7000Acres

Battery Energy Storage System Safety Concerns

Volume 7 Framework Battery Safety Management Plan Document Reference:
EN010142/APP/7.13

Deadline 2 Submission – 14th November 2024

Plate 3-5: Illustrative Battery Enclosure (Source: Recurrent Energy)

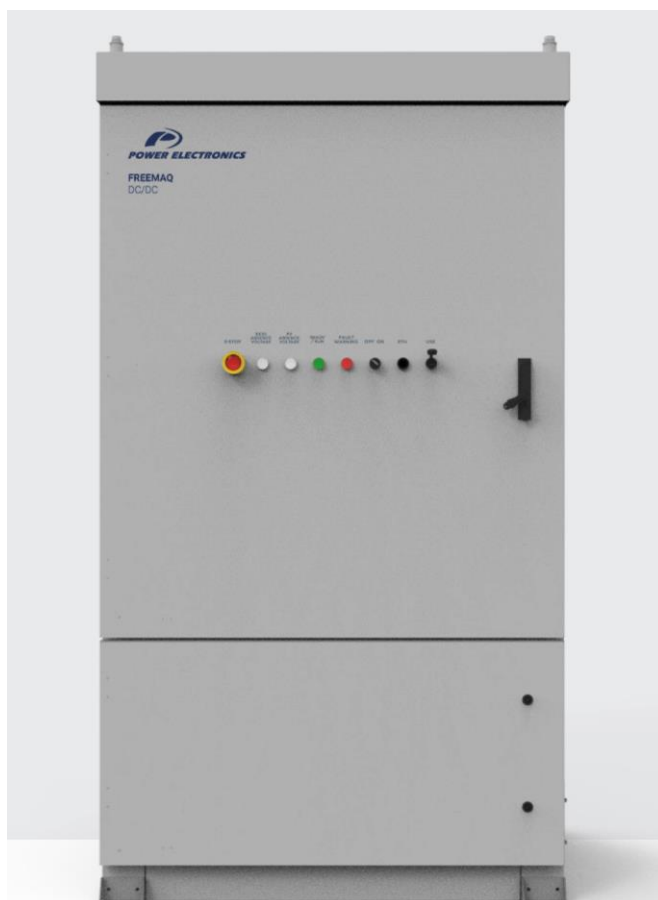
The BESS design does not identify how sufficient water to fight a battery thermal runaway will be provided at each BESS location.

Most of the battery units are shown as being located in the middle of fields, with no mains water available, and yet no stored water facilities are shown. Even for an indicative design, facilities for storing water should be included in the draft design. The current NFCC BESS Guidance states that 1,900 litres of water per minute for at least 2 hours should be available; this will be required for each of the BESS modules, although some collective storage may be possible. As Advice Notice Nine requires the Applicant to apply a “*reasonable worst-case assumption*”, then the design should include the water requirements stated in the current NFCC Guidance. The Applicant's Framework Battery Safety Management Plan paragraph 7.6.2 references the US National Fire Protection Association standard, NFPA 855, which requires a sprinkler system of 0.3 gallons per minute per cubic foot. All design parameters should comply with UK standards, unless it is stated that foreign standards have been adopted as they are higher.

During a thermal runaway, the surrounding area must be cooled to prevent the incident expanding. Therefore, the volume of water held on site must be proportional to the energy storage capacity of the BESS, not just the physical volume of the BESS. This is another reason why the storage capacity of the BESS must be capped, in order to ensure that the water held onsite is sufficient for cooling a thermal runaway and the area surrounding it.
